Administrative Authorization Decision

Application #: 2013-113

Name: Burger Shack

Description: Install a 12'x13' burger shack, with 3'x13' deck, at Silly's.

SHEET TITLE:  
**PLANS AND ELEVATIONS**

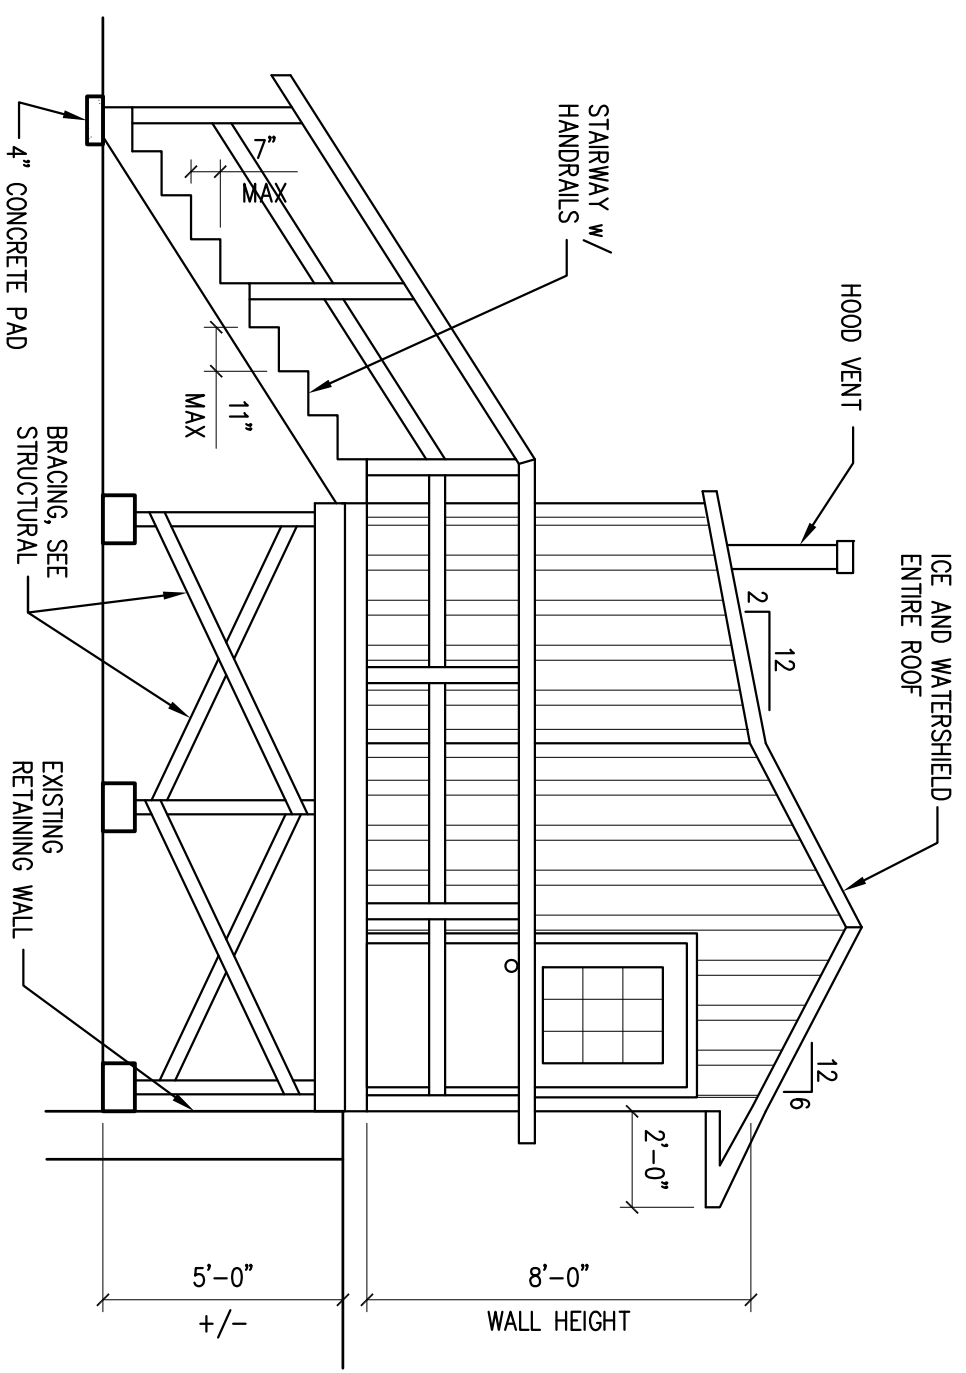
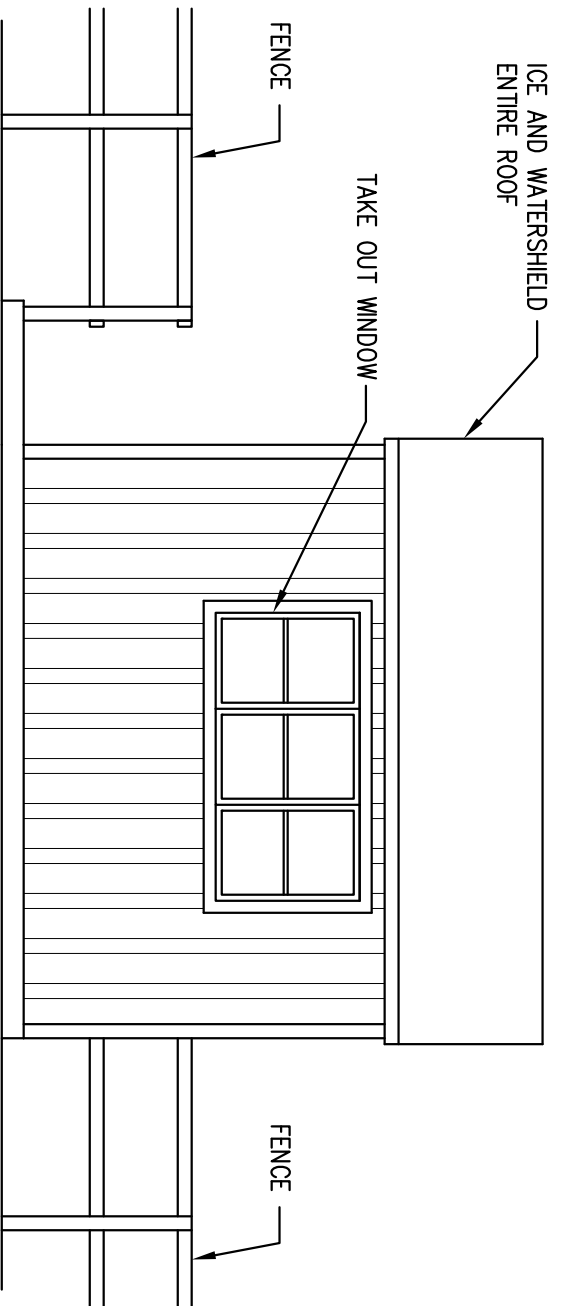
Hi Nell,
They'll need to have an HVAC engineer design and stamp the hood exhaust plans and also change the guard and hand rails to meet code before they submit for a construction permit.
Thanks,
Ben

Good afternoon,
So long as the roof exhaust termination is at least 10 feet from property lines and adjacent buildings it will be fine. When they apply for the commercial hood permit the plans will need to be stamped by an mechanical engineer and show the set backs. They also will have to let the engineer know that the building is combustible construction so they can plan on the clearance reduction methods that will have to be employed.
Thanks,
Ben

Note that, per the city's Fire Prevention Bureau, the roof exhaust termination must be at least 10 feet from adjacent property lines and buildings. This does not constitute approval by the Fire Prevention Bureau, which has indicated that additional information is required. For additional comments, contact Ben Wallace, 874-8400.

Drawing file: 4. Revised Plans / Site Plan w utilites.pdf

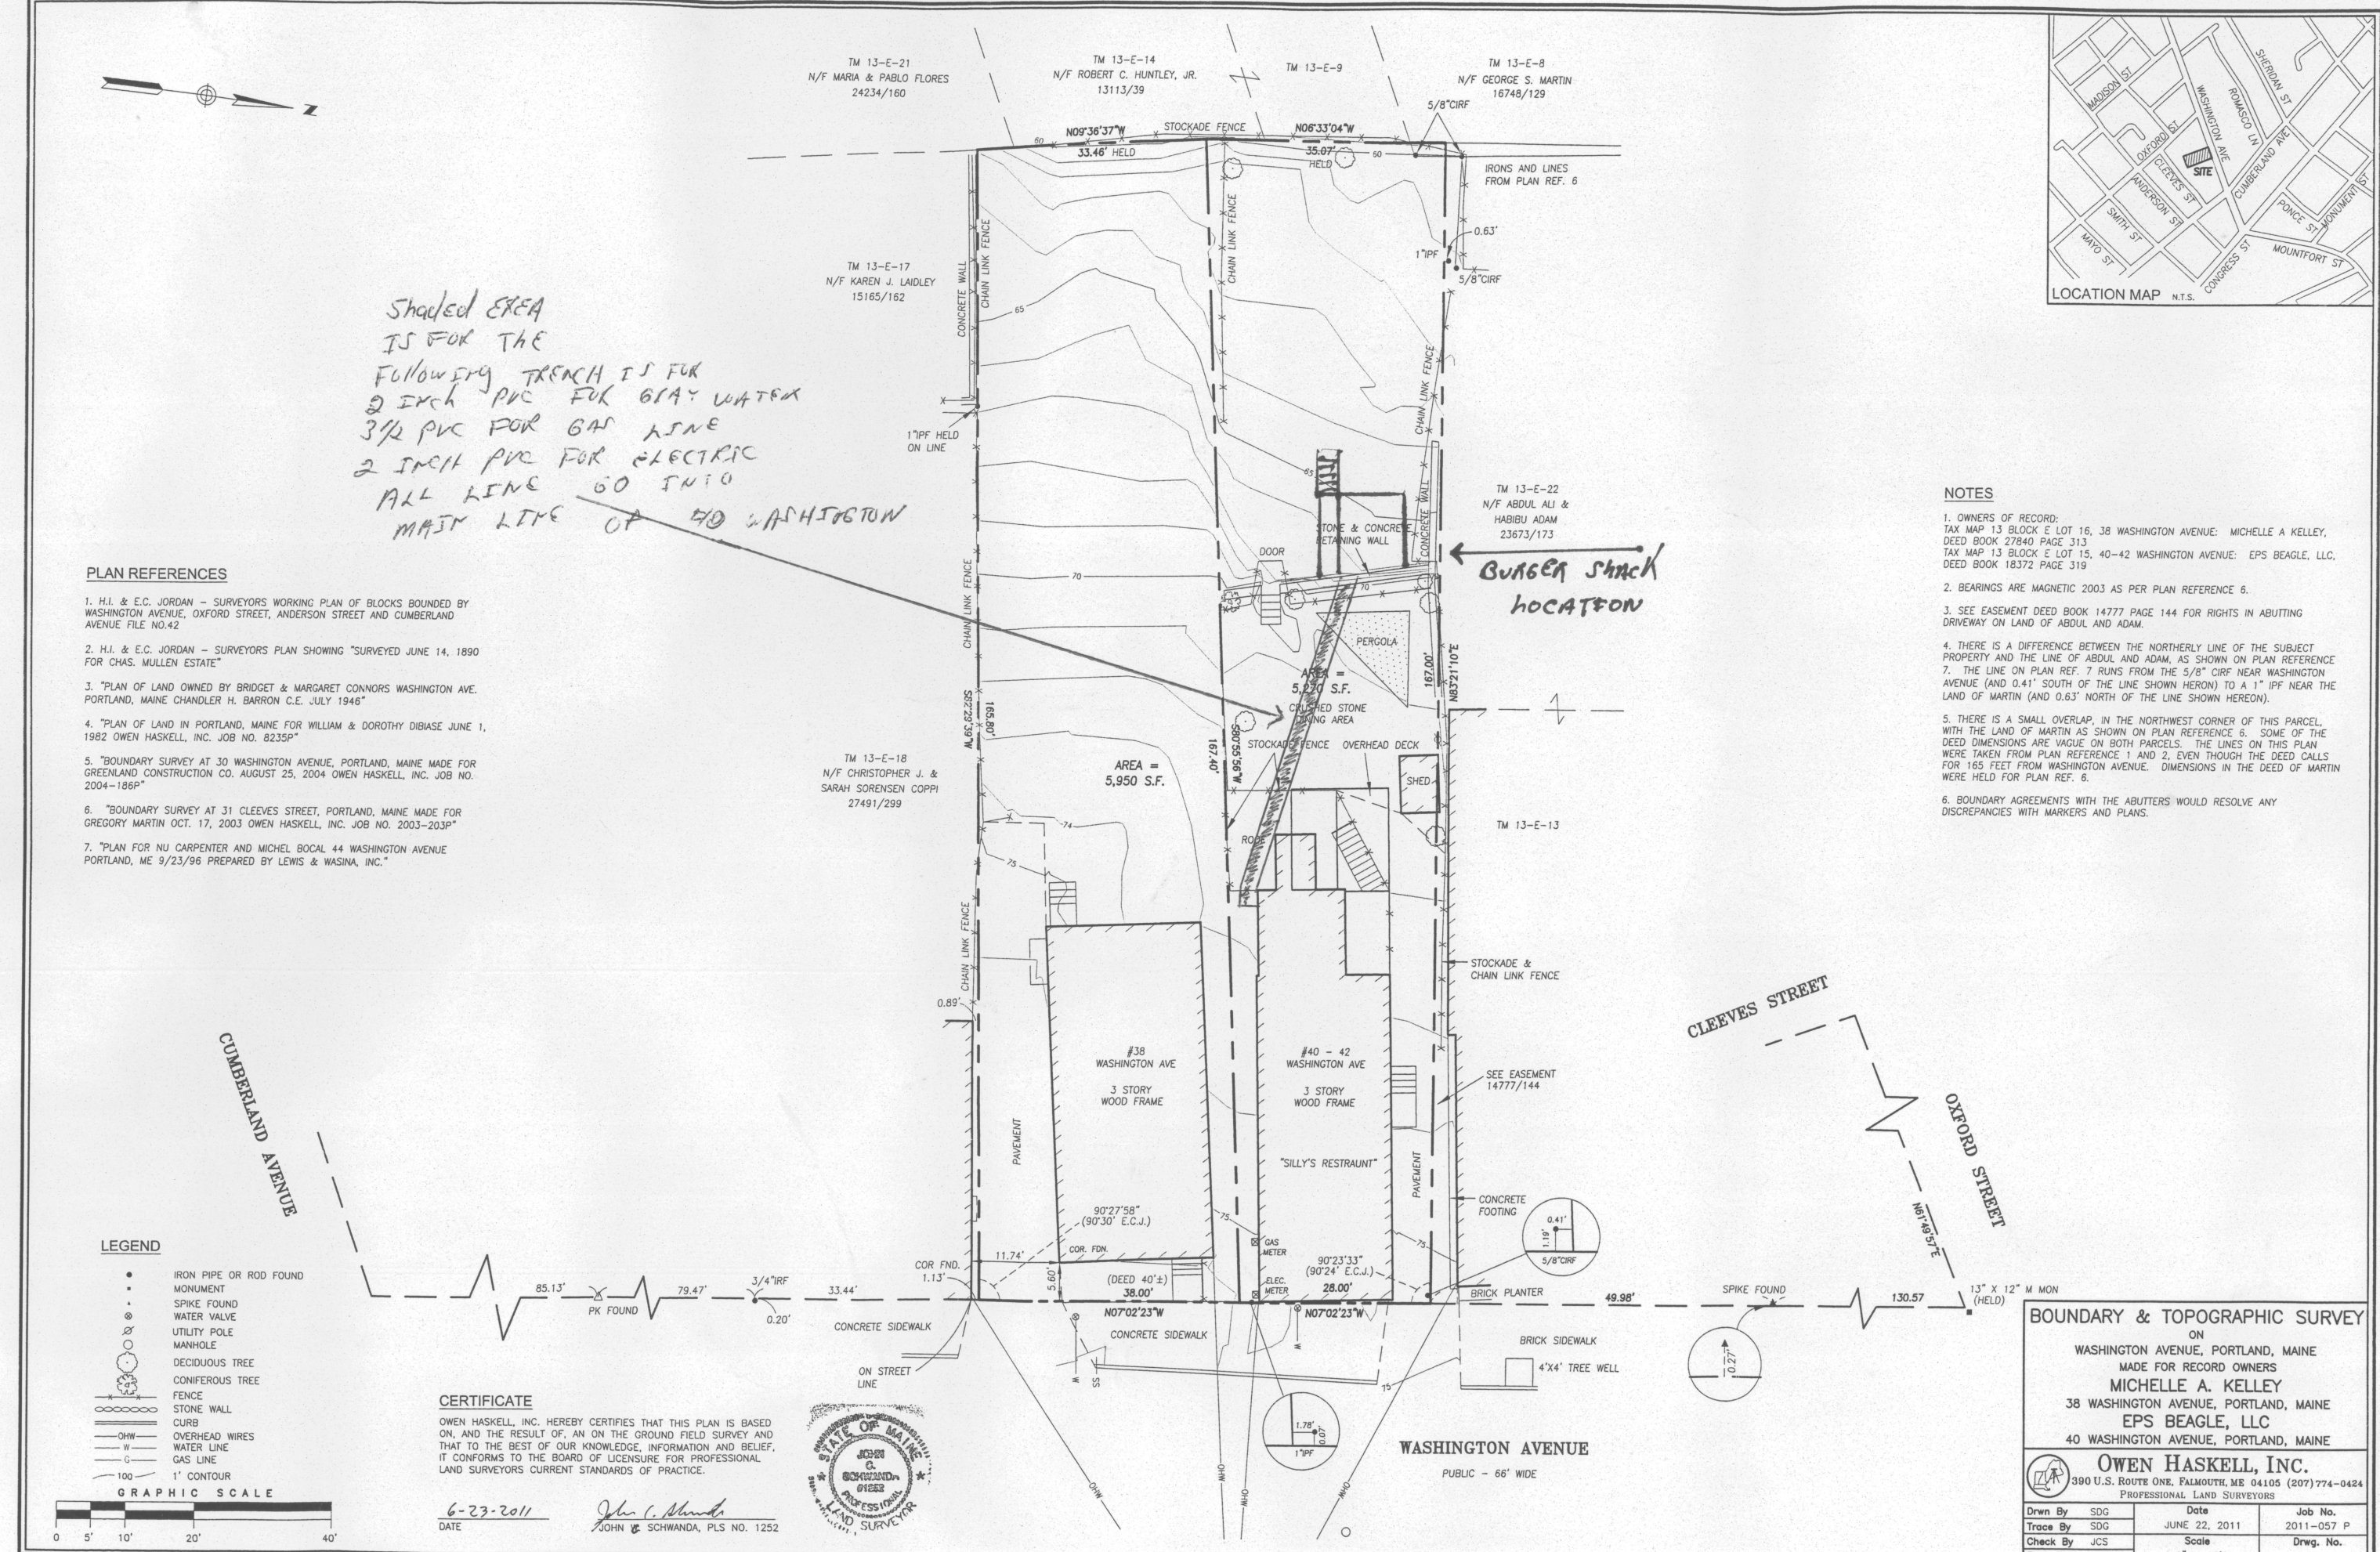
We would like additional information to review the application for Silly's Restaurant. I am requesting an updated site plan for this restaurant showing the existing and proposed wastewater drains, the existing grease trap, and point of connection to the sewer system. I am requesting a schematic diagram of the facility plumbing system that includes enough detail to show which existing and proposed drains would be connected to the grease trap (s). I also request information regarding the size, make and model number (if known) of the existing external grease trap.

In spite of the restaurant owner's indication that the sinks in the Burger Shack will not be used for washing, I think we have to assume that the new sinks will be used at some point in the future. Therefore, the drain from the Burger Shack should have a properly sized grease trap. Our preference is for drains from food preparation and dish washing areas to be routed through a properly sized external grease trap. If there are site specific constraints that preclude an external grease trap from being used, an internal grease can be considered. Thus, it seems appropriate to ask the applicant if the drain line from the Burger Shack can be routed through the existing external grease trap and if the existing external grease trap has the capacity to accept the flow, from the Burger Shack. If the external grease cannot be used in this situation, and an internal grease trap is proposed, it seems appropriate to ask what make, model, and capacity grease trap is being proposed and how this unit size was selected. We can provide guidance regarding grease trap sizing if that would help.

Prior to certificate of occupancy, the applicant shall install a grease trap, sized based on flow, to service the proposed burger shack. Specifications should be reviewed and approved by the city's Department of Public Services in advance of installation.
